Please note: All comments generated during the 3rd review are based on the WQ design changes from a sand filter basin to runoff reduction

EPC STORMWATER REVIEW COMMENTS
IN ORANGE BOXES WITH BLACK TEXT

**FINAL DRAINAGE REPORT
FOR
A-1 CHIPSEAL
LOT 36 AND 37 CLAREMONT BUSINESS PARK FIL NO 2
7245 COLE VIEW
COLORADO SPRINGS, COLORADO**

TNE Job No. 2173.00
County Job No. COM-22-014

PROPOSED DRAINAGE MAP

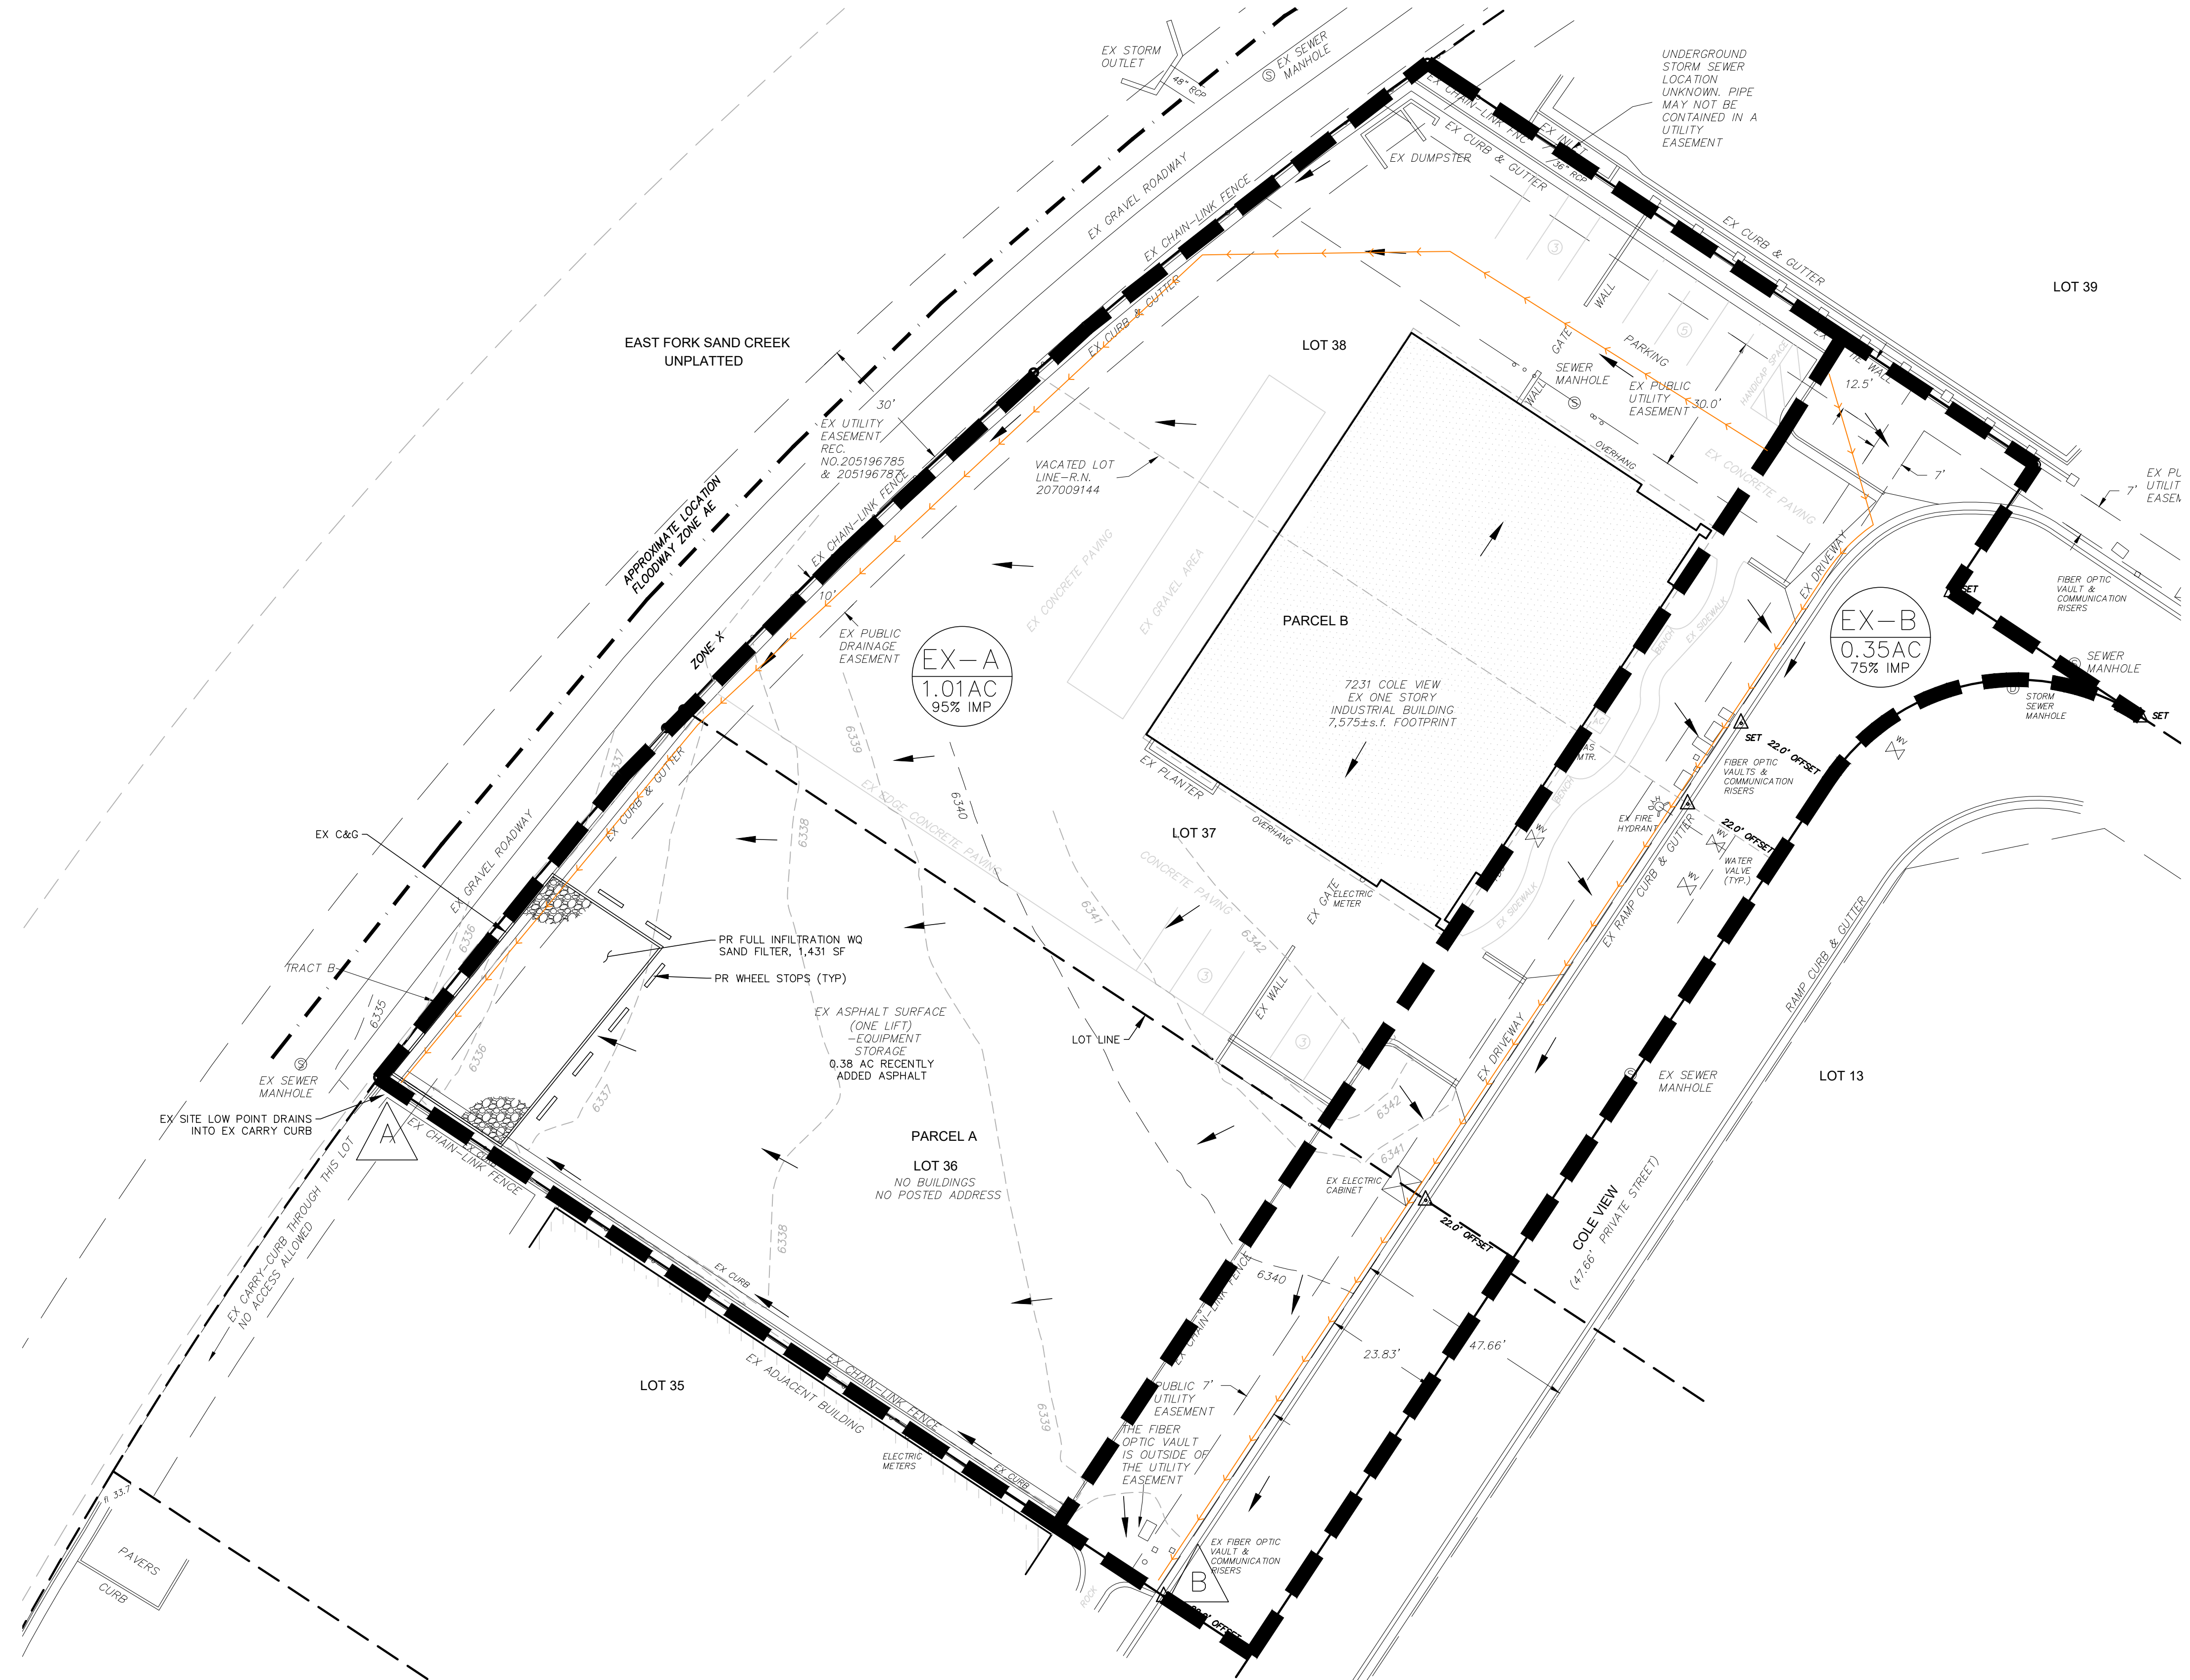
provide in appendix
